From: Hill, Grace <Grace.Hill@e-lindsey.gov.uk>
Sent: 16 April 2026 10:12
To: Niland, Mark
Cc: _planningadvice
Subject: H09-0306-26 - ecology comments

H09-0306-26 - Bakkavor Sluice Road Holbeach St Marks Spalding PE12 8HF
Proposed demolition of existing temporary classroom building & erection of new classroom

Client		Bakkavor	
Project Title			
Solar Project			
Drawing Title			
Proposed Ground Layout - 3D and section			
Scale (@ A1)	Date		
1 : 100	Jan 2026		
Drawing No.	Drawn	REV	
368_07	MJF	A

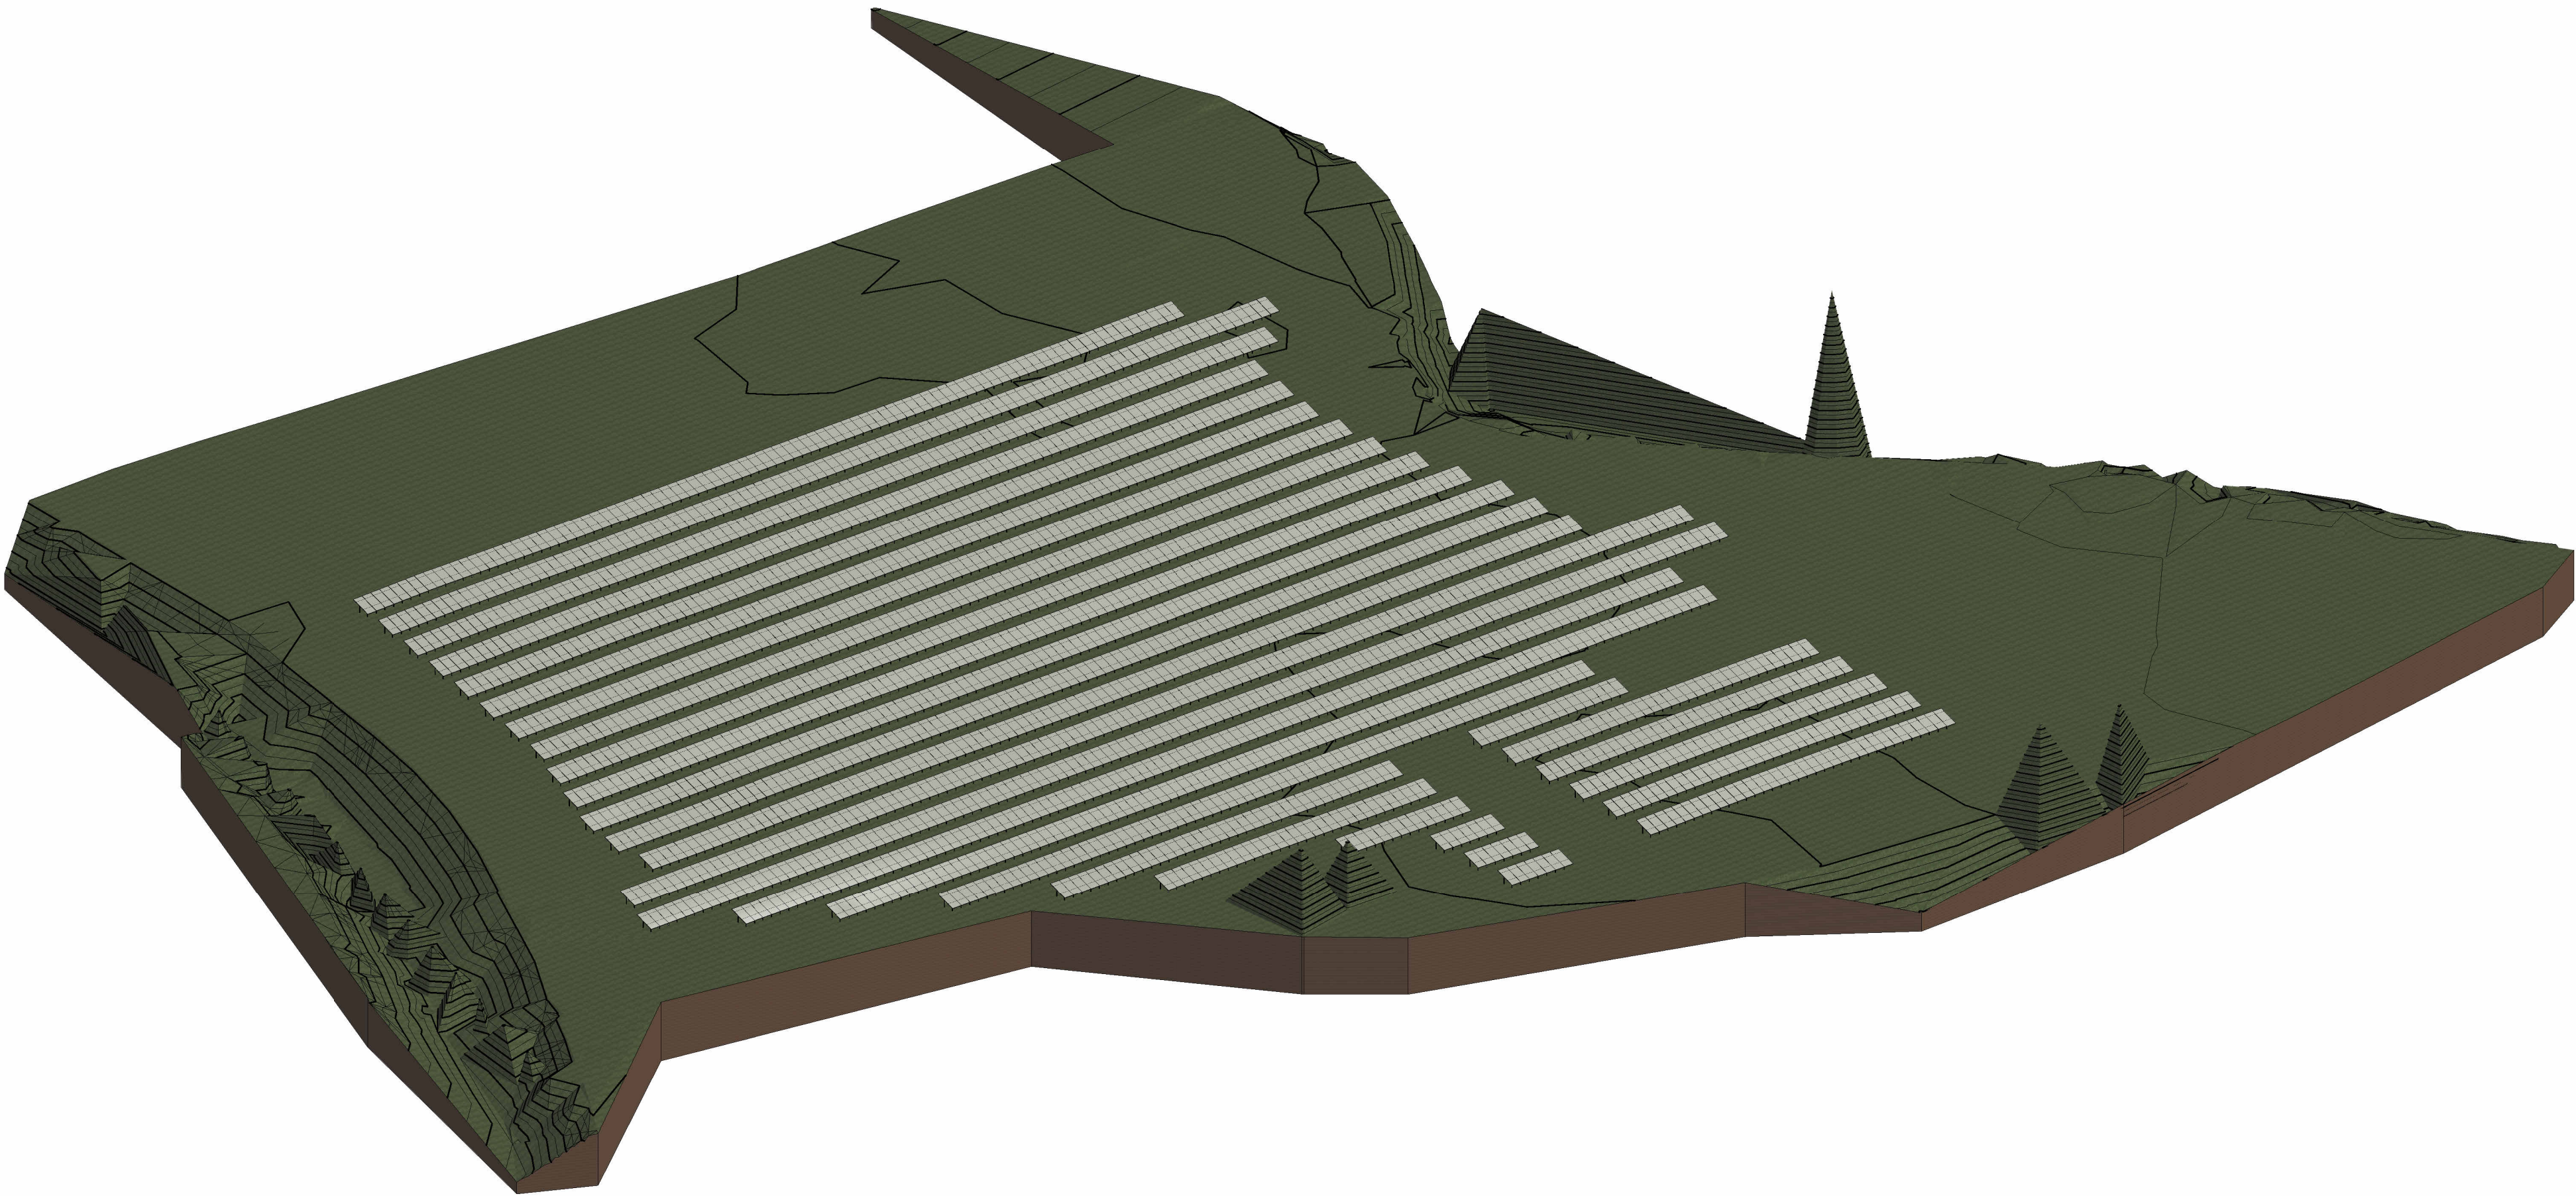
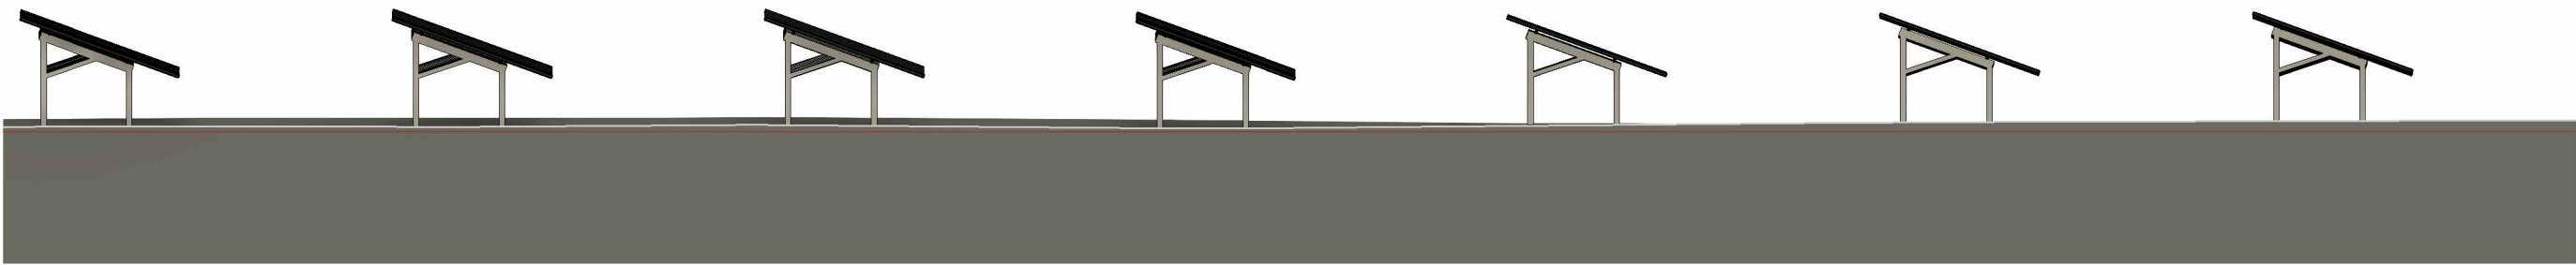
- We require the habitats surrounding the solar arrays to be altered to comply with the UK habitat classification system version 2.01 which states that developers should: Record the strips of [solar] panels as u1b6 [Developed Land; Sealed Surface, a habitat which does not deliver Biodiversity Units] and the strips of vegetation in between the rows separately.

- Following these guidelines we have estimated that the total area covered by the solar arrays would be roughly 0.5375 ha. This area should be recorded in the created habitat tab of the metric as 'developed land/sealed surface'.

- That would mean that roughly 0.8224ha would still remain in the created habitat tab as 'moderate condition other neutral grassland (ONG)'.
- We request that the habitat created between the solar arrays be altered from 'ONG in moderate condition' to 'ONG in Poor condition' or 'Modified grassland in Moderate condition' due to the relative complexity of creation ONG mod under these conditions. If the habitat ONG poor is created, then 11.61% net gain can still be achieved for this site with 3.06 units being created by this habitat creation.
